Subject: FG/24/20/HH

I am writing to you in respect of the planning application referenced in the subject line of this email.

As I wrote in my comment, this "development" is NOT a simple garden room; For further clarification, it is a full annex, in which a kitchen has been installed and is either being used as an additional residence or as a workshop, neither of which is a permitted development. What provision, I would ask, has been made for the resulting strain on the drainage system? The whole site is now virtually paved over, which also increases the risk of surface flooding on my property and that of my neighbours.

East Front Elevation

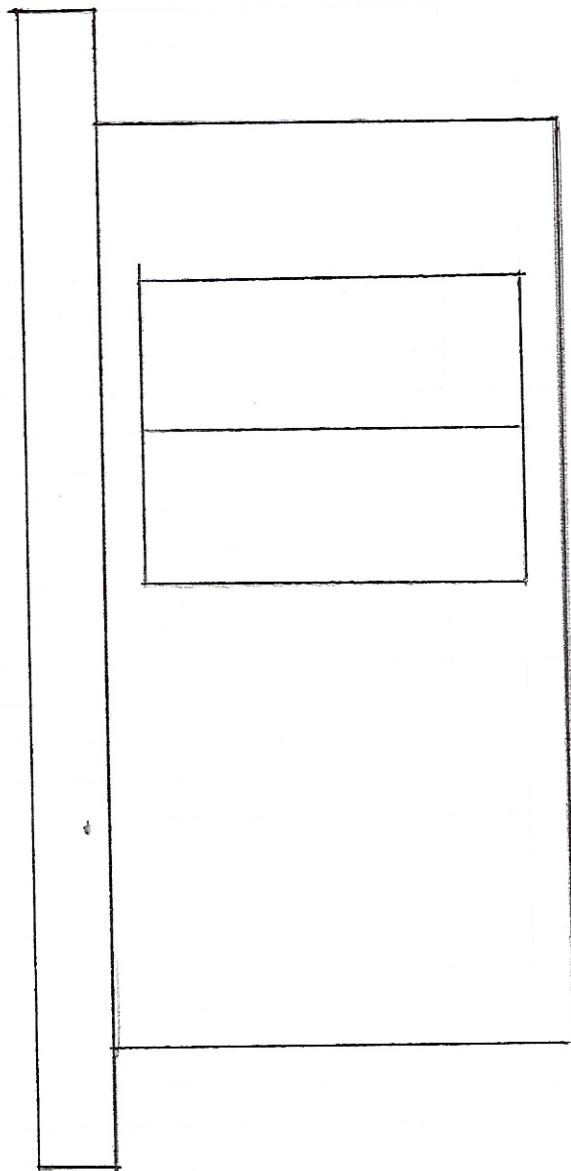
The "annex" further contravenes planning regulations as, together with the footprint of the house, it clearly takes up more than 50% of the space. It is more than 2.5 m high and is NOT more than 1 m away from my (or my neighbours) boundaries.
